Your Ref: OWPC24463
Our Ref: AW/246/19/PL
Please ask for:
Mr S Davis

Town & Country Planning Act 1990 (as amended)
Town and Country Planning (Development Management Procedure) (England) Order 2015

Erection of 1 No. 2 storey end of terrace house.
Land Adjacent to 34 Wakefield Way Aldwick

PROJECT	Wakefield Way	DATE	19/08/19
TITLE	Site Plans	DRG NO	IBA/520/01
SCALE	As Noted	REVISIONS

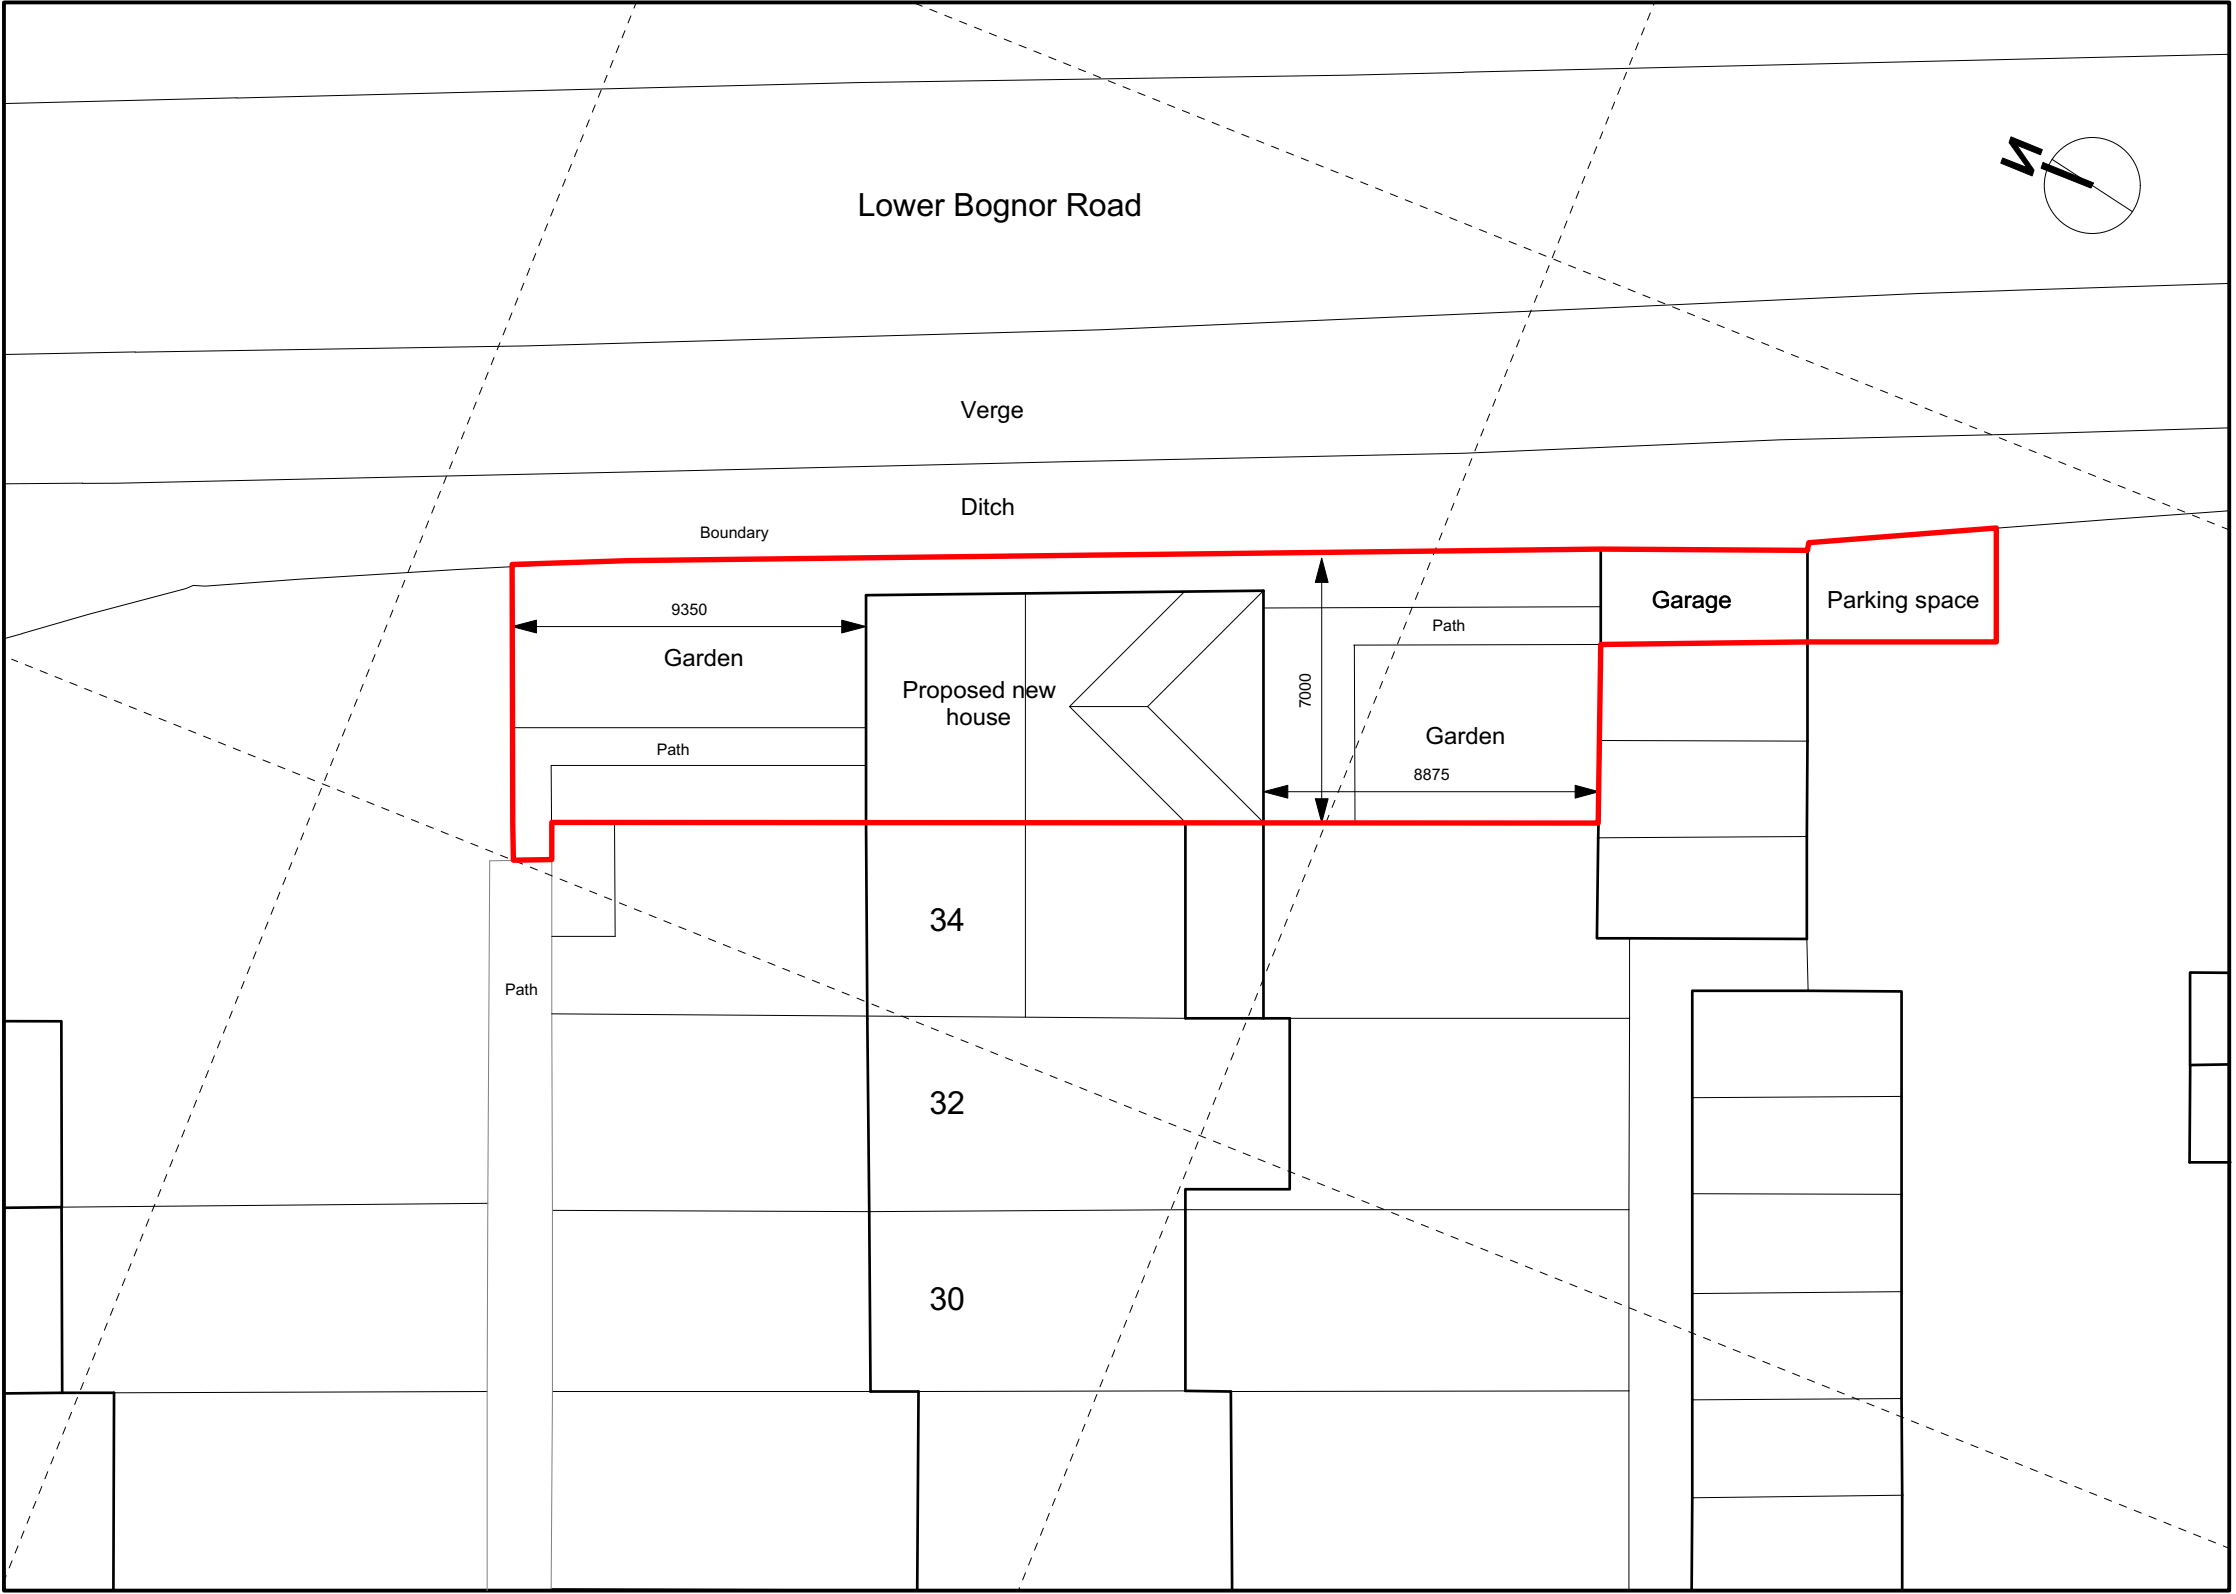
Members had no objection to the application, however, they expressed concerns about the loss of parking and garage for the existing building and the need for cars from the existing building to park outside the garage precinct in an already congested area. Further, Members considered that parking for the proposed new building is inadequate.
